TRAFFIC IMPACT STUDY

Jaynes Property
El Paso County, Colorado
PCD File No. SKP225

November 2022

## SKETCH PLAN

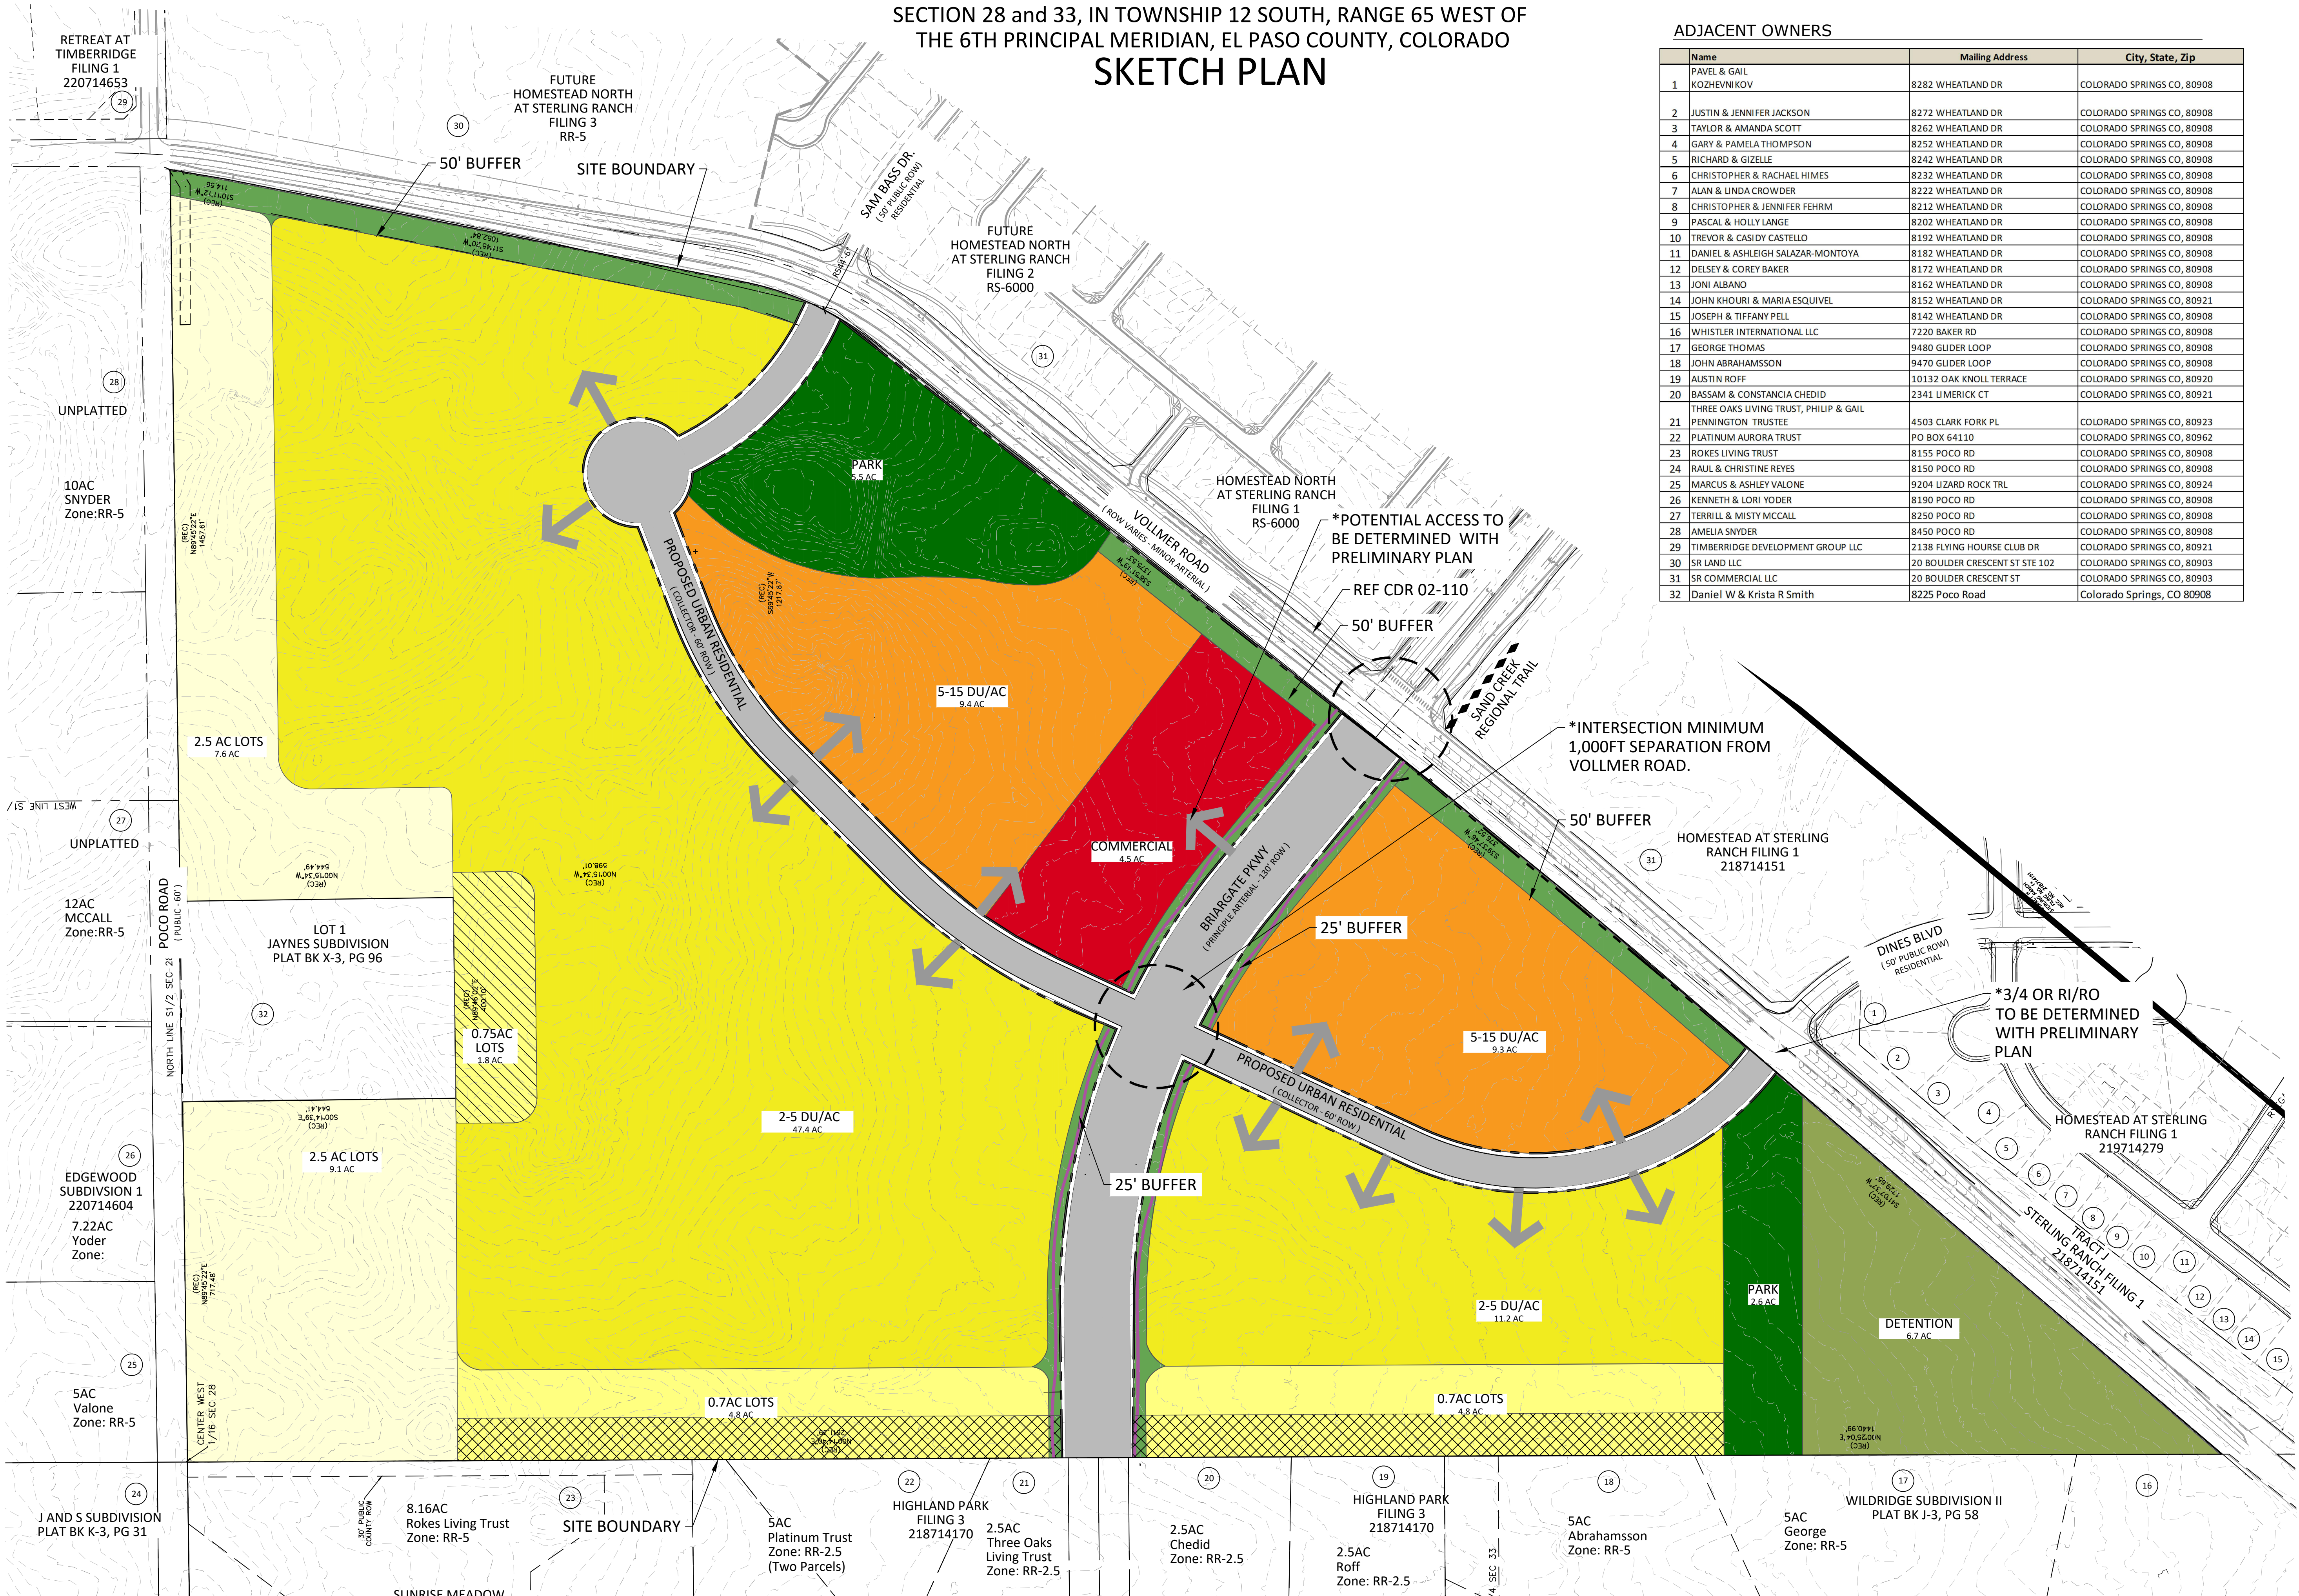
Clarify - full movement is unlikely here; possibly RI/RO or 3/4 only because of vertical alignment on east side.

Delete this arrow

We understand that a sketch plan is conceptual, but the location of this intersection will reduce the chances of any additional access being granted between here and Vollmer Road. The intersection should be approximately 400-500 feet from the west property line on the ridge, at least 1,000 feet to Vollmer Road.
